MEMORANDUM

DATE: April 23, 2022

SUBJECT: **On-Call Contract #17-067H-1; PO # 8115428**
Traffic Impact Study Reviews
Task Order #3: Flying Horse North Sketch Plan TIS Review

SHEET
SP.1

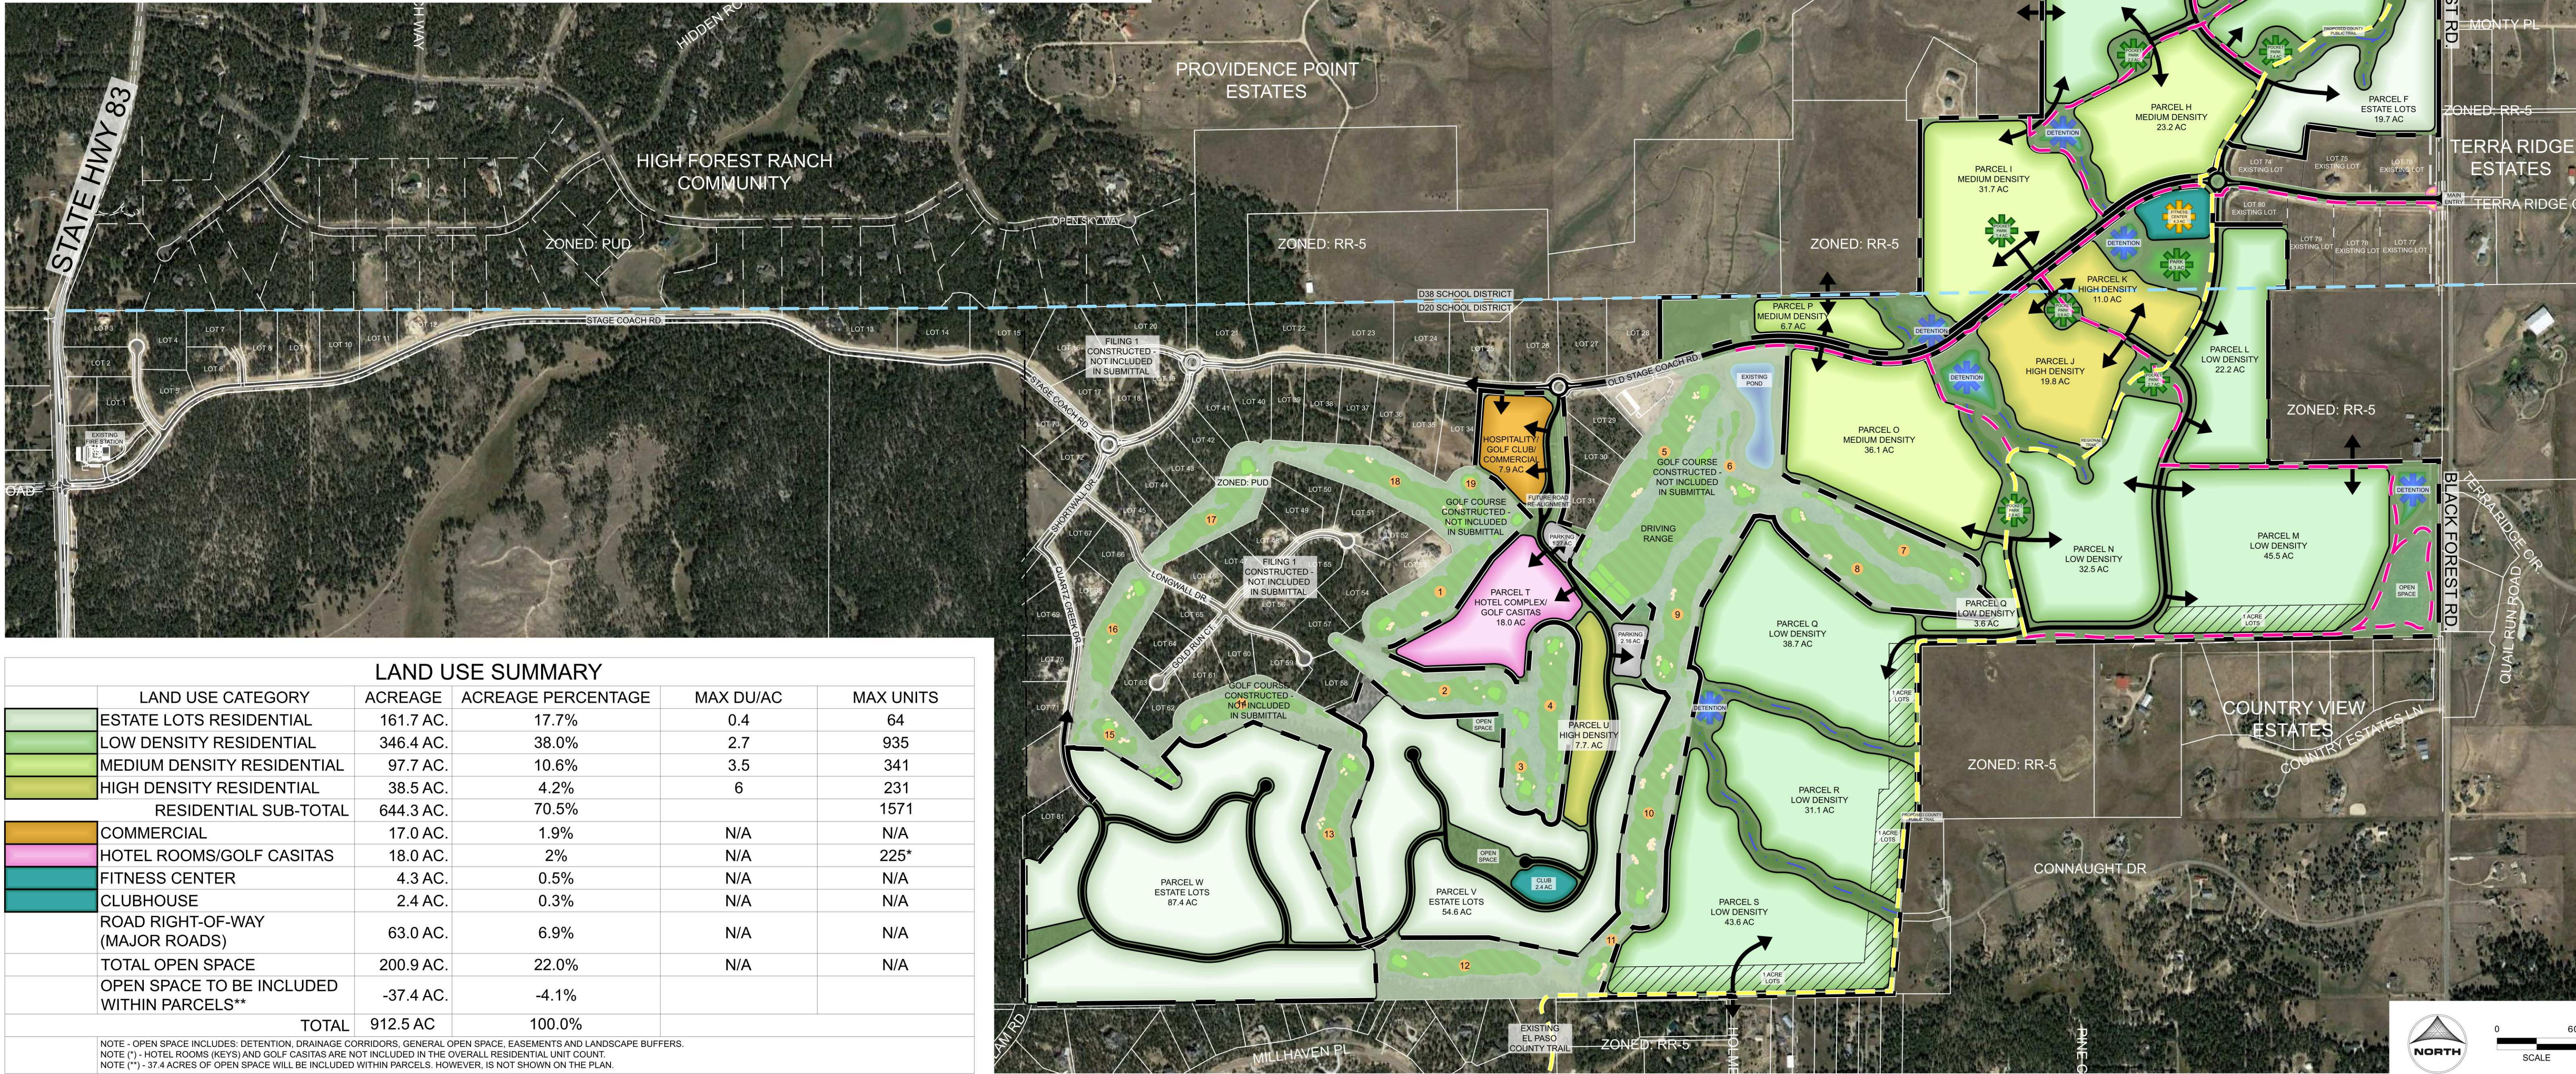
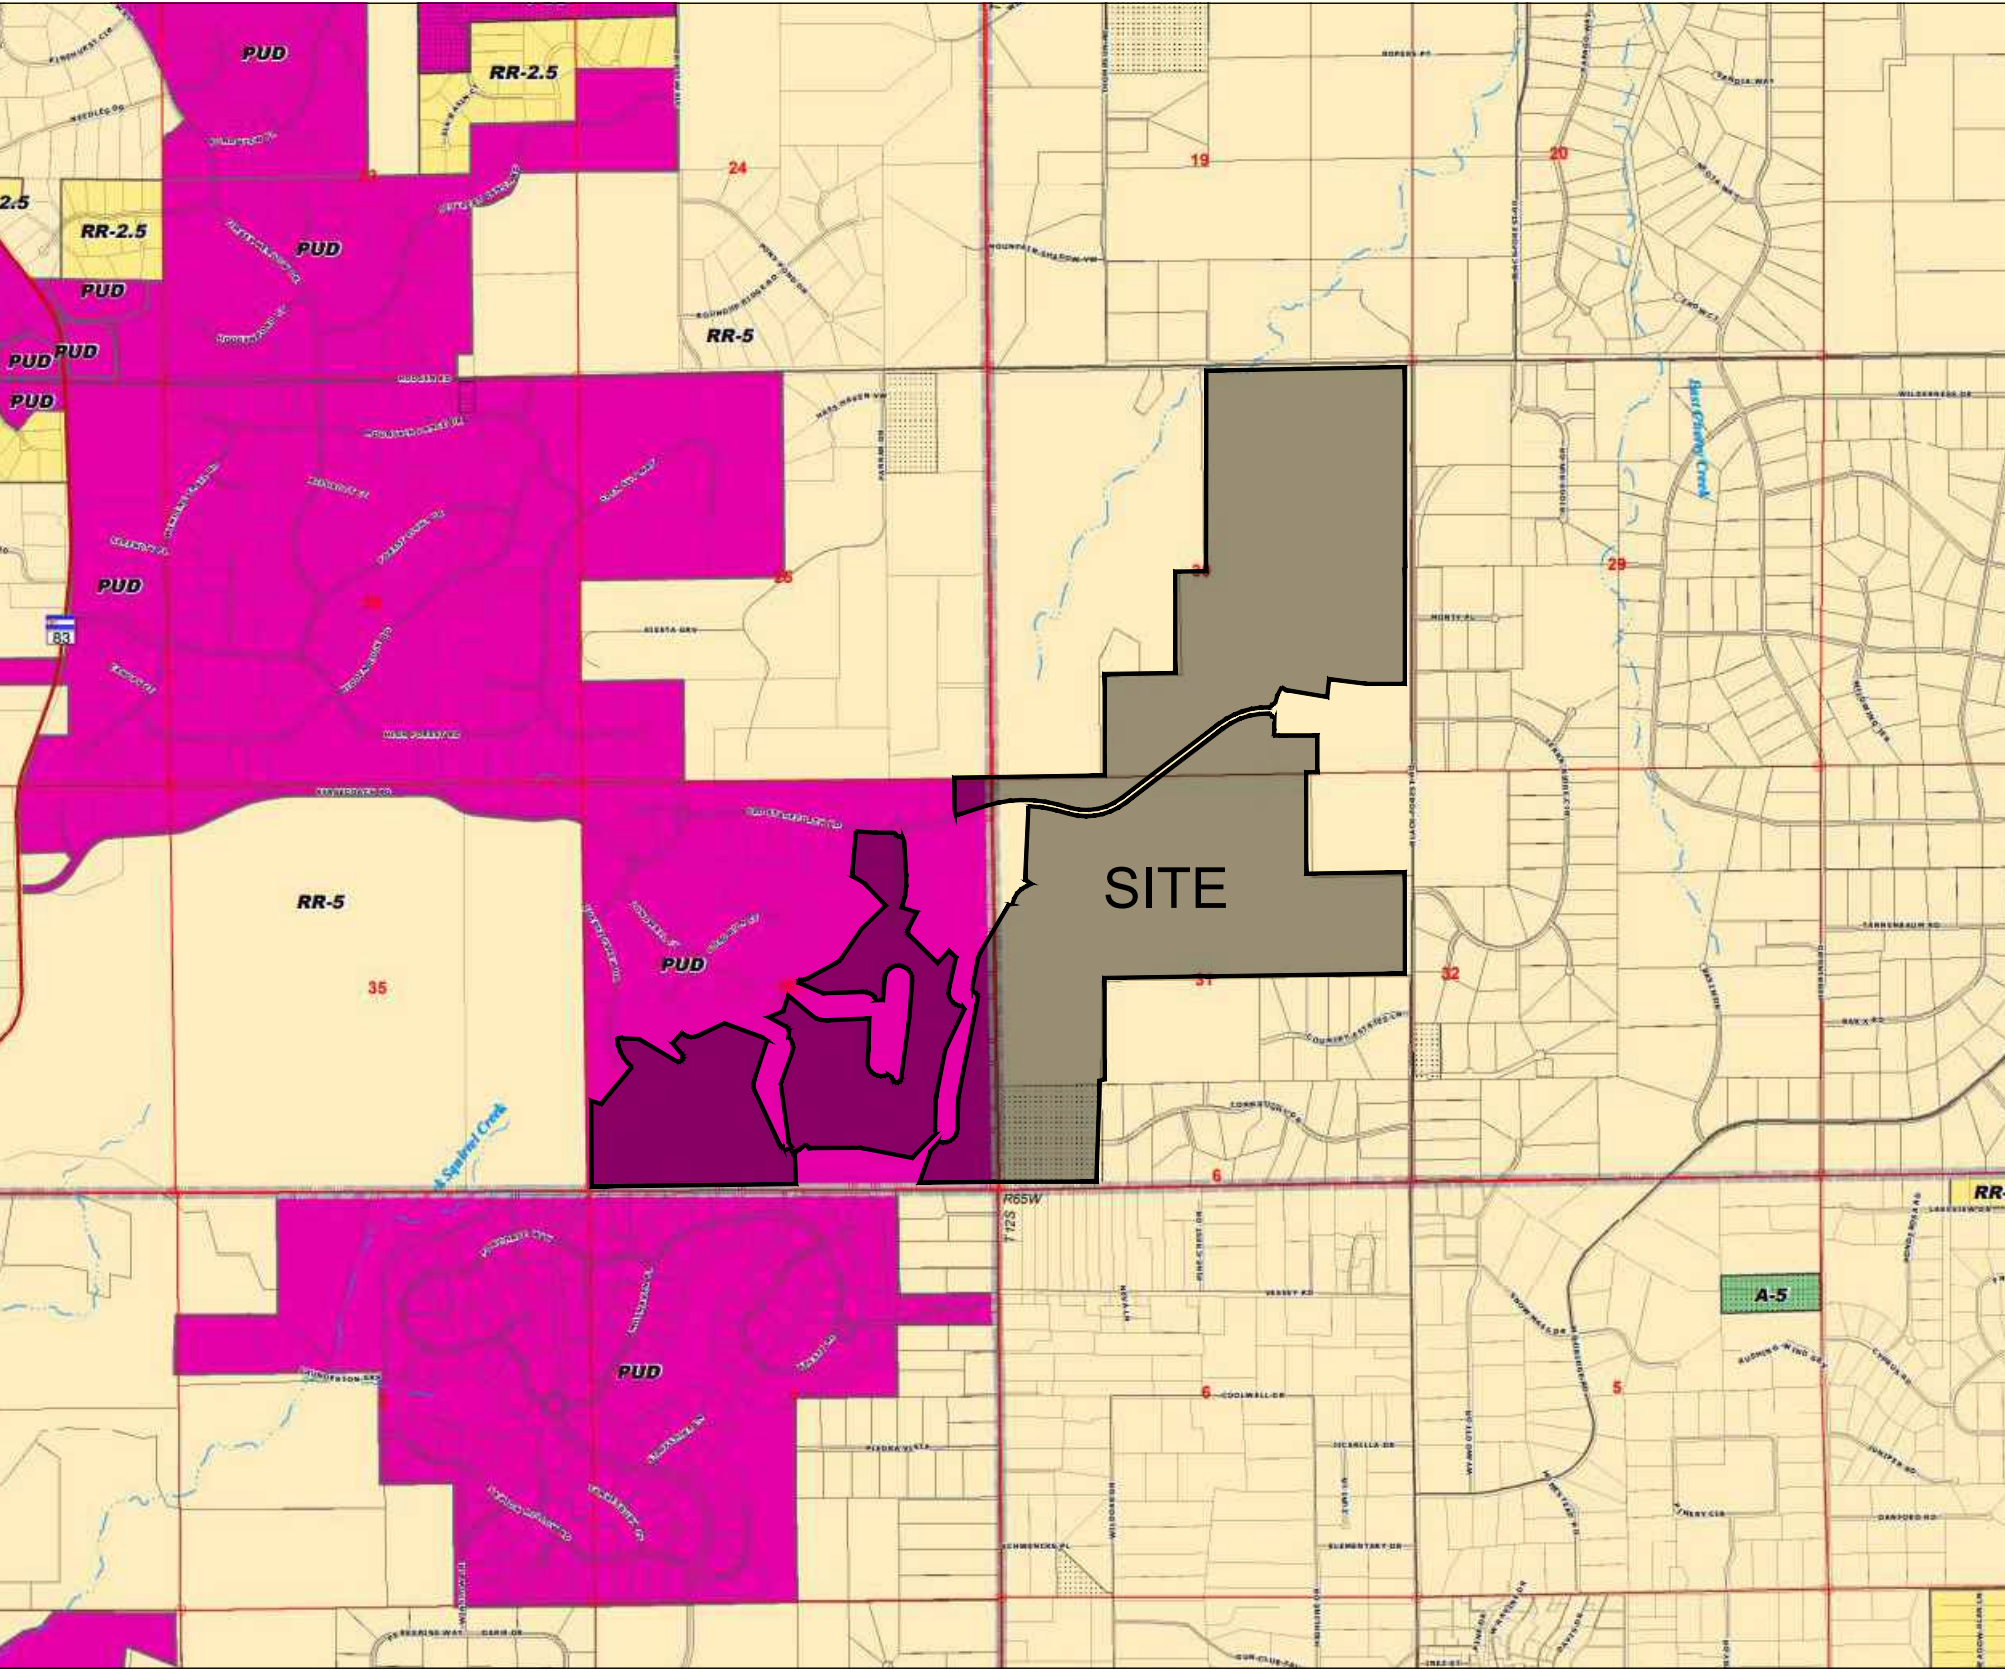
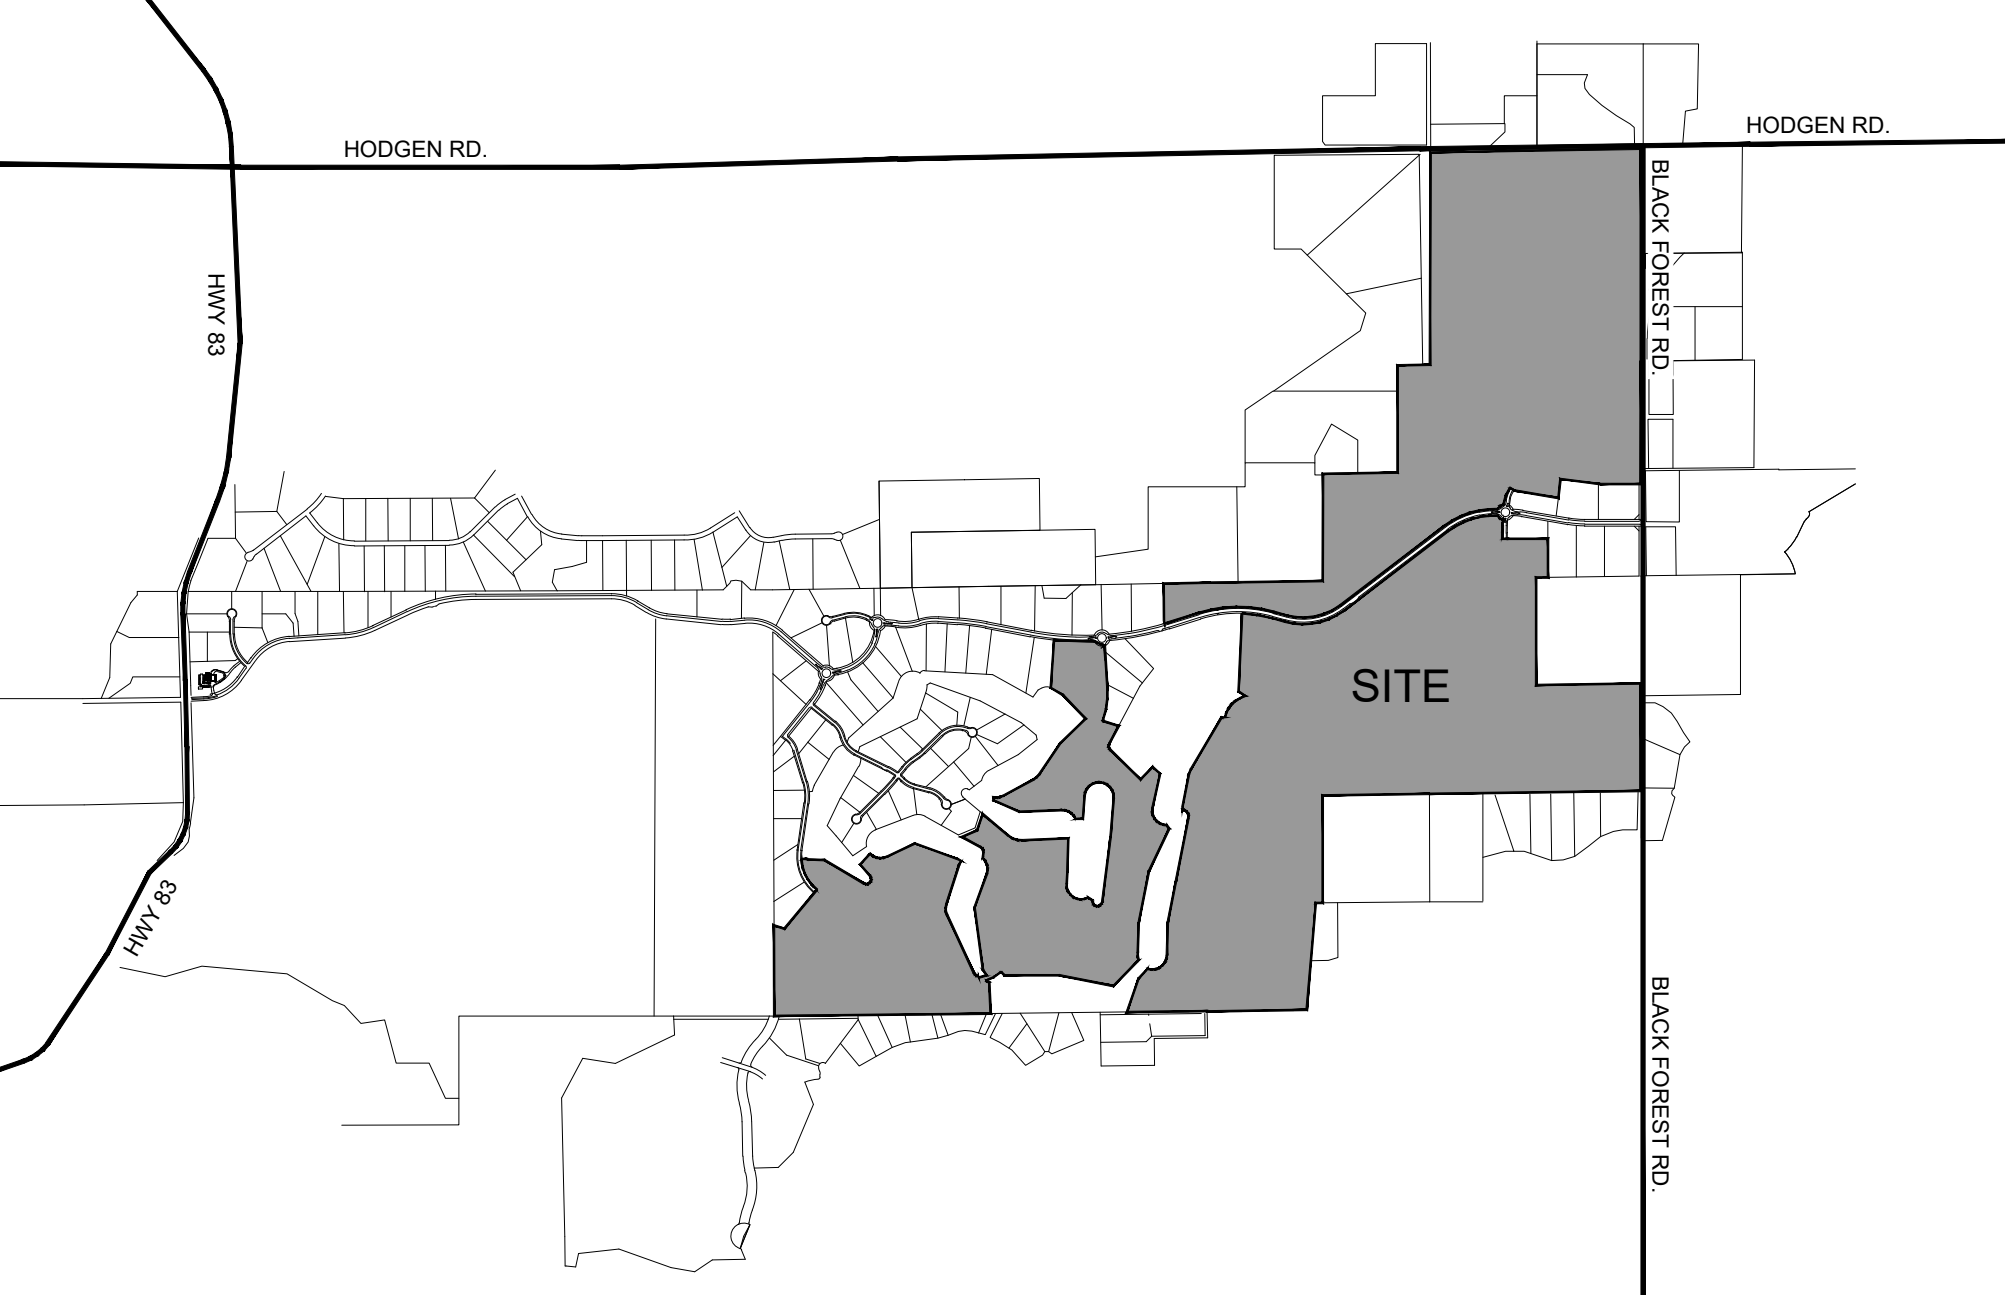
- General Note 1 on Sheet 1 refers to 1,471 DU while the remaining sketch plan sheets and the TIS refer to 1,571 dwelling units. Clarify.
- There are references to City of Colorado Springs requirements on Sheet 1. Clarify if the City's requirements will also apply to the TIS, or if this is in error in the Sketch Plan.
